Recommendation Report for Planning Permission for Works or Extension to a Dwelling

REF NO: FG/157/12/

LOCATION: 2 Langbury Lane
Ferring

PROPOSAL: Two storey rear extension (Resubmission following FG/110/12)

**FRONT
PROPOSED ELEVATIONS**
Scale 1:100

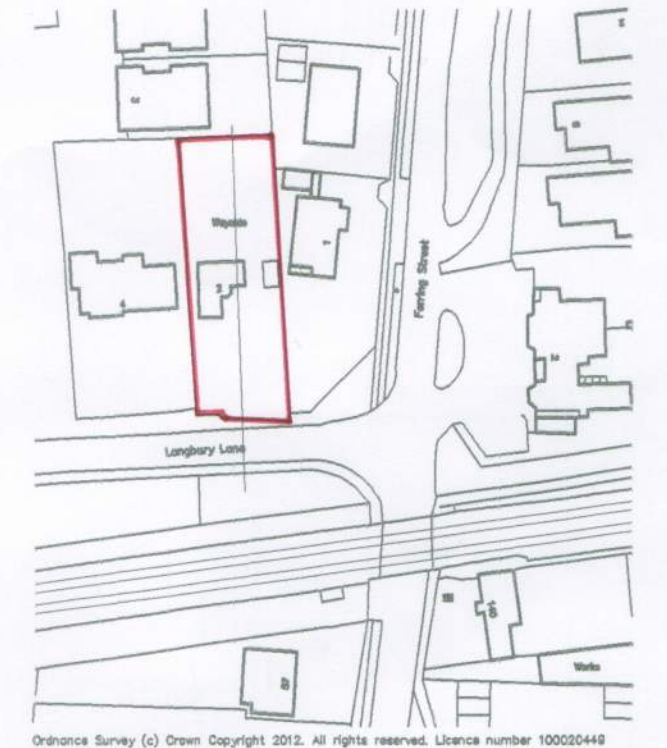
Proposal differs from refused FG-110-12 by changes to fenestration on the rear and eastern elevations and the inclusion of an additional window to the second floor on the western elevation facing No. 4 Langbury Lane which serves a bathroom and is obscure. Changes were made following discussion with Council.

The proposed new extension is two storeys with a hipped roof, and measures 4.5 metres to eaves level and approximately 7.3 metres to the top of the roof ridge.

The pitch of the roof results in a vertical emphasis which is relieved by the proposed windows.

The western wall is approximately 1.6 metres from the western property boundary, and approximately 4 metres from No. 4 Langbury's eastern side wall and rear patio. It is not considered that the proposed extension will result in an overbearing effect on No. 4. No privacy impact will occur due to condition requiring obscure first floor window.

No. 1 Ferring Lane is located immediately to the east of the proposal site. The property has its principal elevation onto Ferring Lane and contains a number of habitable rooms to its rear. The separation of the extension from that boundary is 6m which is sufficient. The proposed extension includes a large window on the eastern elevation at first floor level which is conditioned to be obscured. This window is situated approximately 8 metres from the rear elevation of 1 Ferring Lane. The proposed window will not be detrimental to the residential amenity of the residents of No. 1 Ferring Lane.

- 4 The windows on the eastern and western elevations at first floor levels must be obscure glazed to a height of 1.7m above finished floor level.

**GROUND
PROPOSED FLOOR PLANS**
Scale 1:100

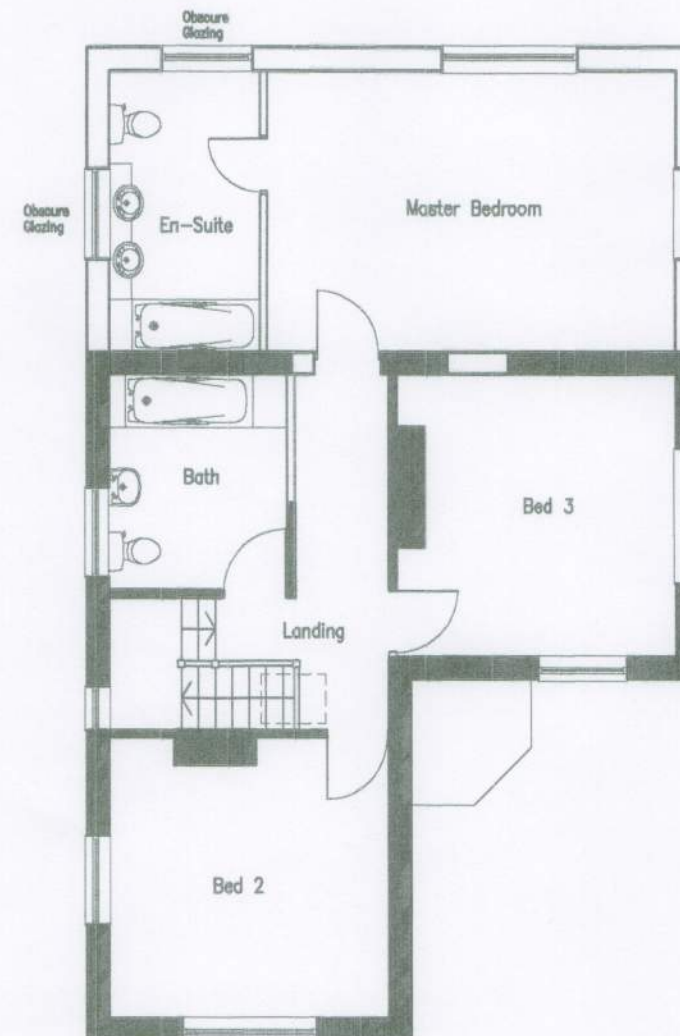
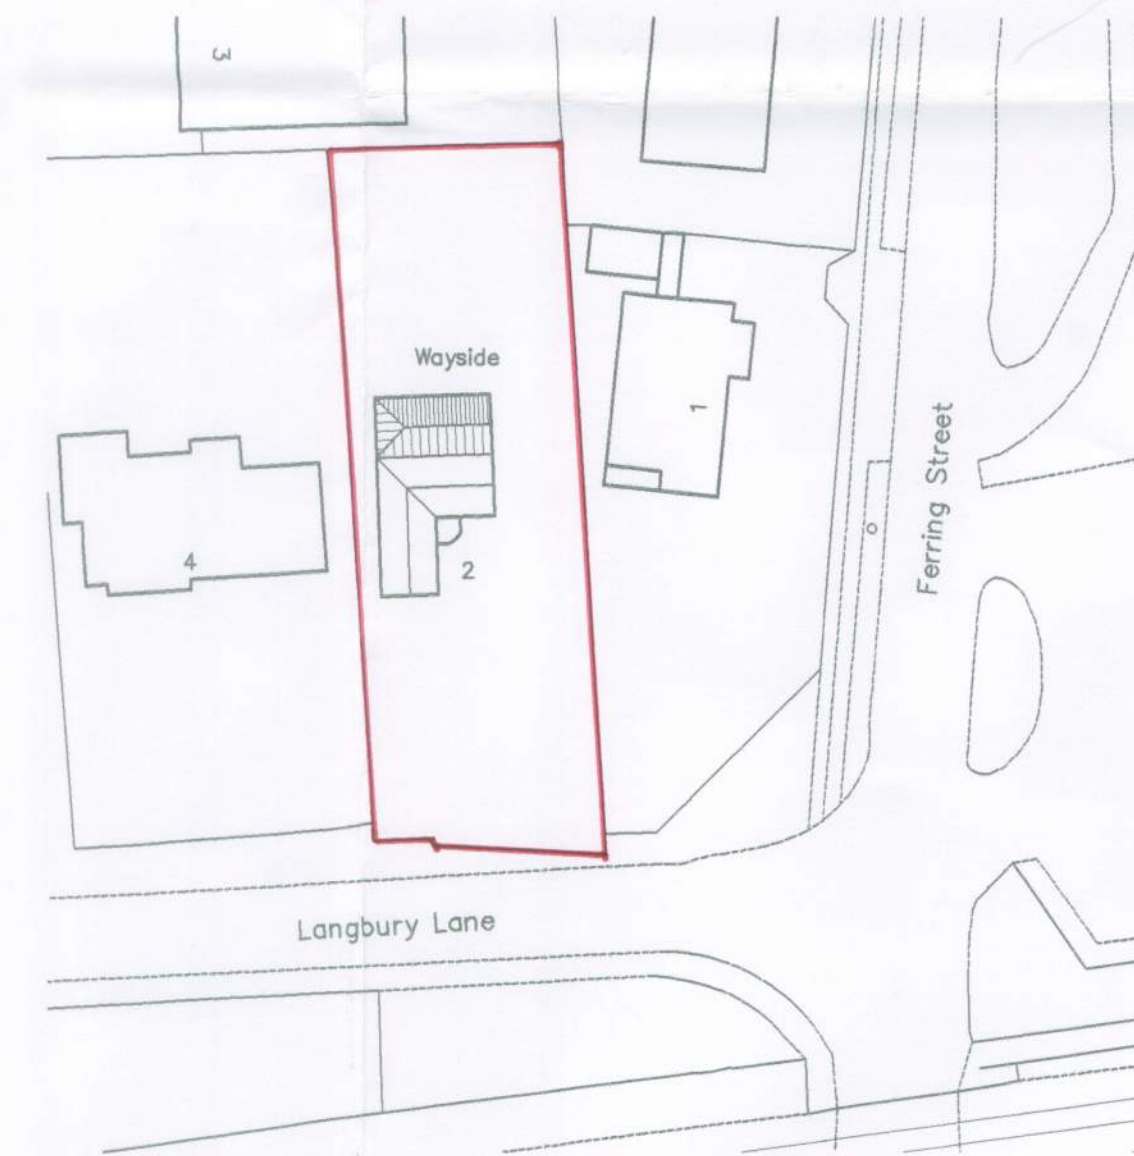
The proposed extension is located 6m from the shared boundary with No. 1 Ferring Lane and will not result in a material adverse impact to that property in terms of overbearing and loss of daylight. There is a large first floor window in the proposed extension which faces toward No. 1 Ferring Lane, 8m from first floor windows in that property. A condition is recommended requiring obscure glazing, subject to this, it is considered that the privacy impact caused would not be material for residents of No. 1 Ferring Lane.
